**The Sizewell C Project: EN010012**

**Deadline 10 submission**

**COMMENTS on submissions at D8 and D9 made by Sylvia Ballard concerning BRIDLEWAY 19**

DRAWING TITLE:
 CONSTRUCTION PHASE

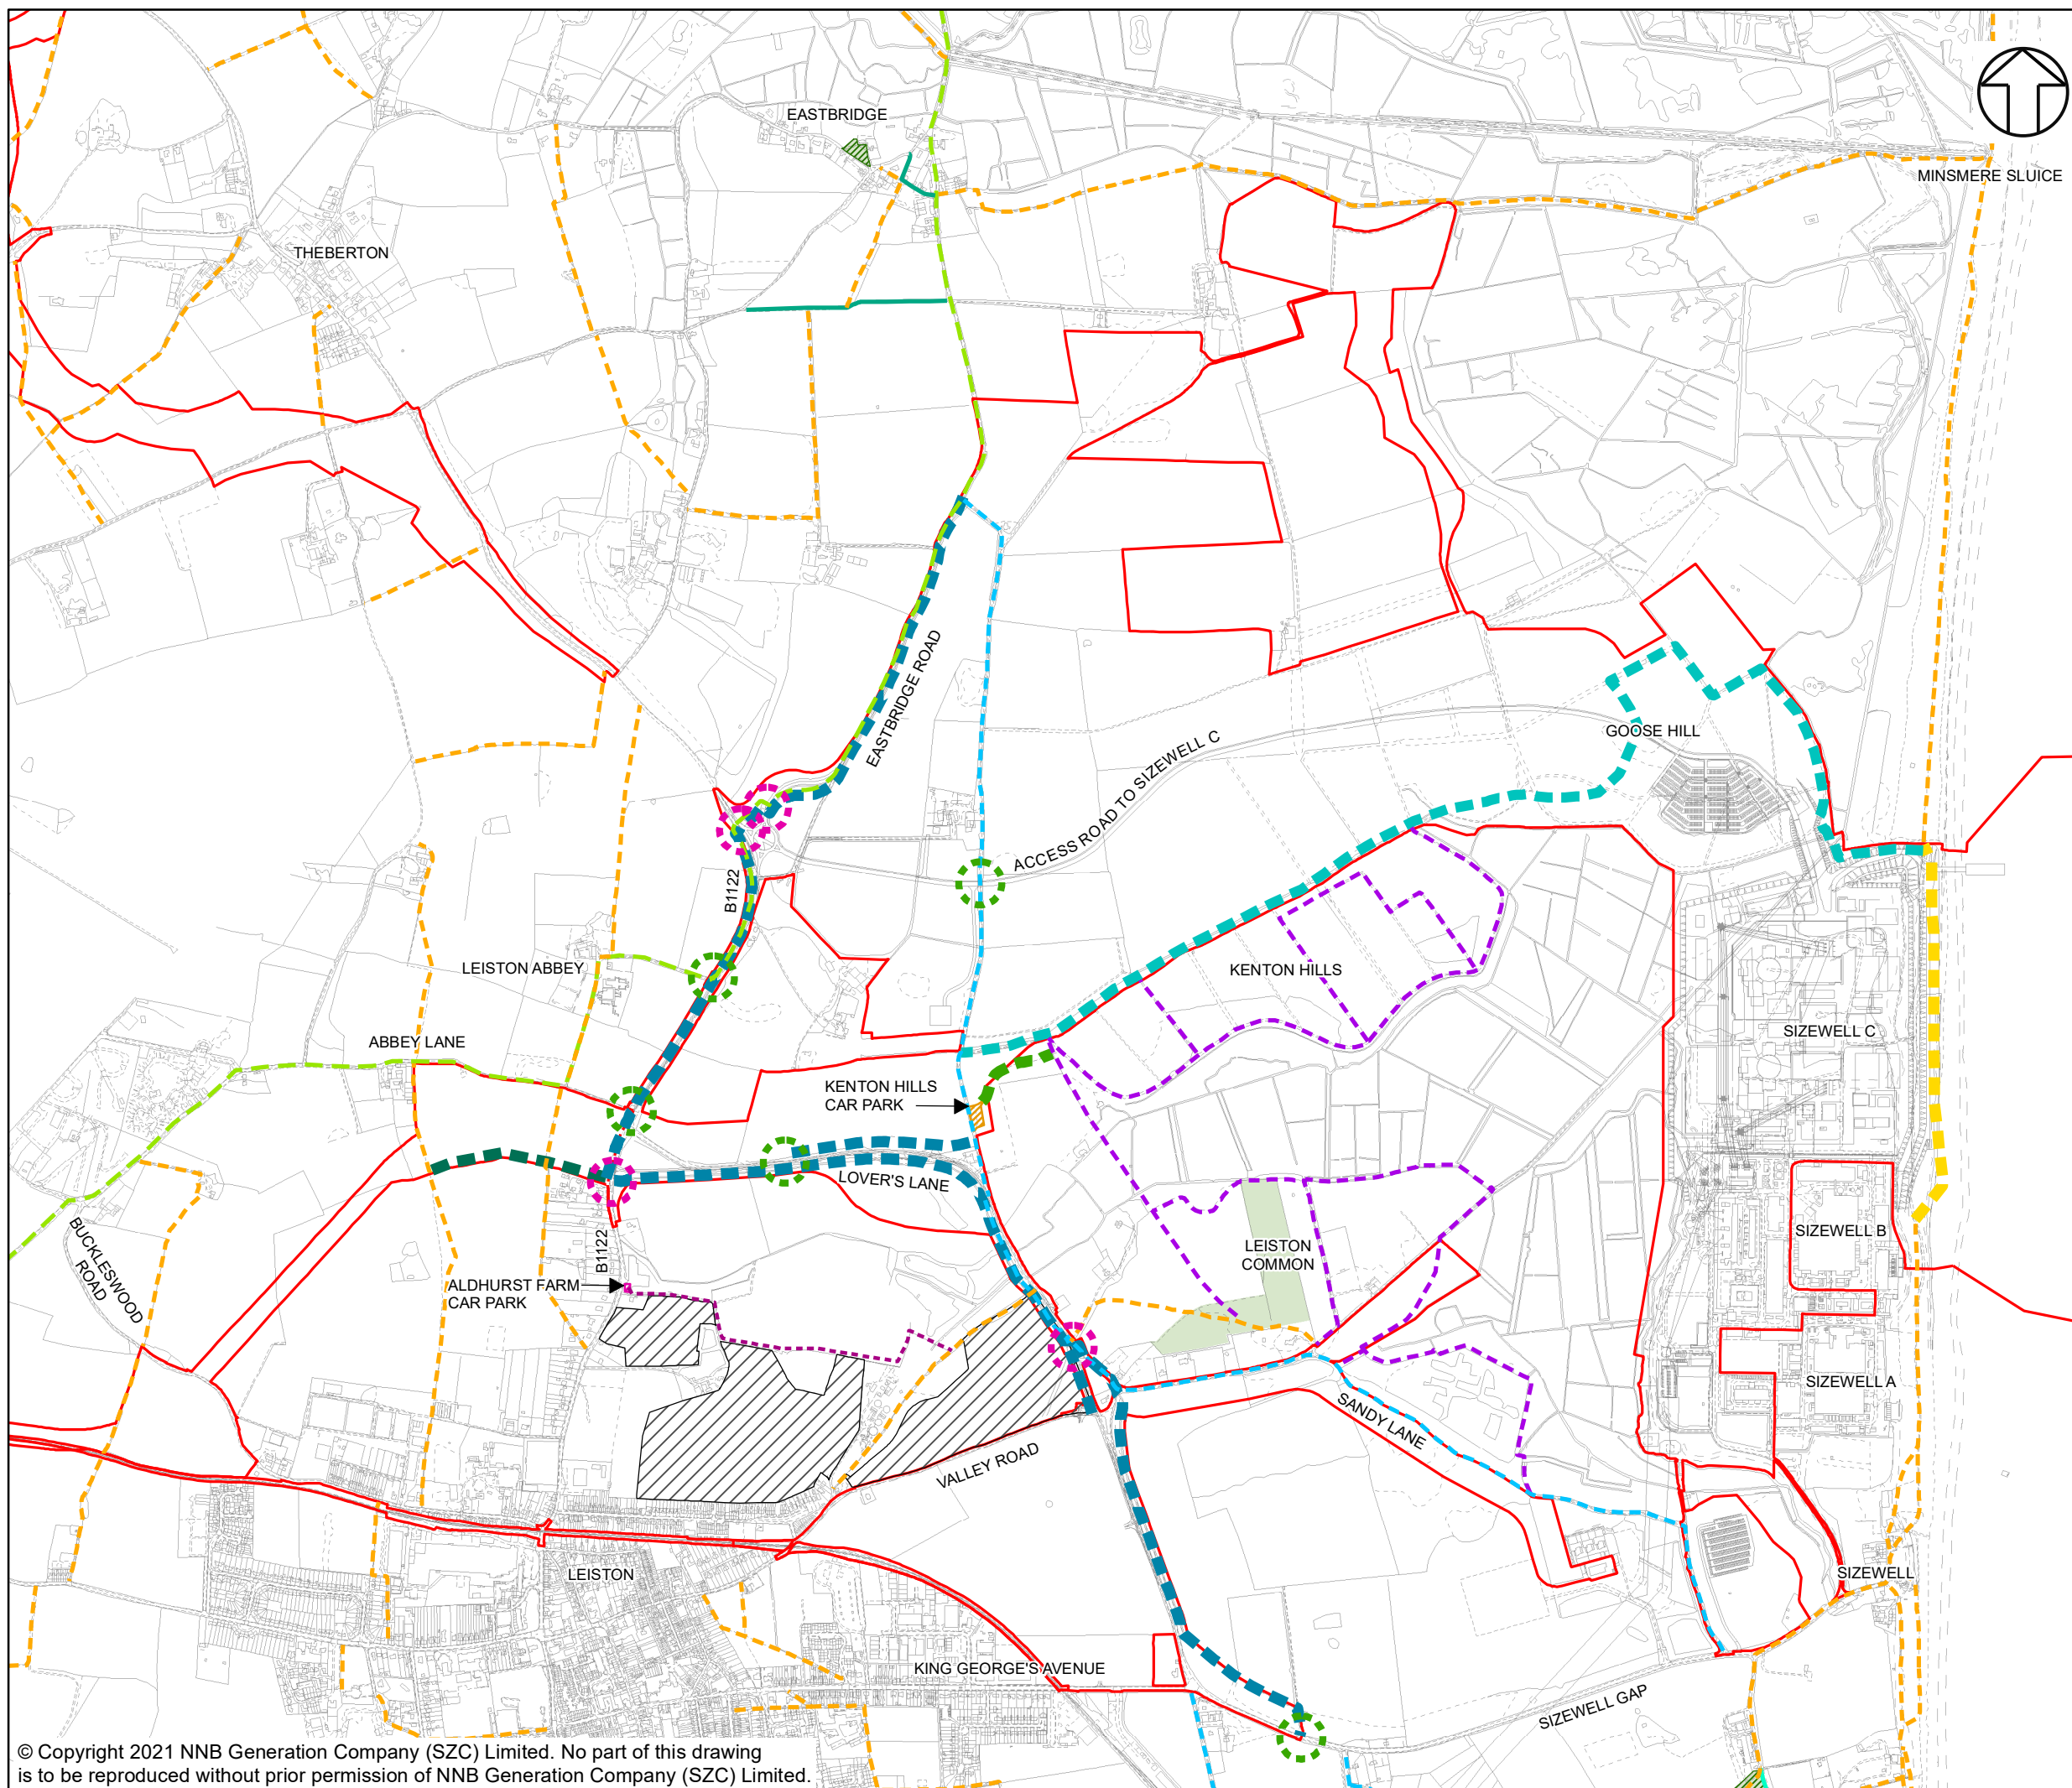
The proposed temporary diversion route for Bridleway 19 on to the combined bridleway and cycleway cannot be completed until the initial stages of proposed construction of SZC are completed, but as Bridleway 19 currently runs through the centre of the construction site this popular public right of way will need to be diverted on safety grounds before any works on the SZC development site can commence.

The route of Bridleway 19 is regularly used, and during the proposed construction of SZC this right of way, or its temporary diversion, will also carry the many walkers diverted from using the Coastal Path and Sandlings Walk. A suitable and safe alternative must be provided for Bridleway 19 that is open and available at all times, with no temporary closures of any kind or duration.

Our main concern is further north, where Bridleway 19 passes through the proposed construction site. As it is so regularly used, a suitable and safe alternative must be provided to any part of it stopped up. Yet, according to AS-261, the proposed alternative route would not be in place for pedestrians until after the initial construction stage and not at all for equestrians until the entire construction of SZC is complete. Needless to say, this does not comply with highways regulations.
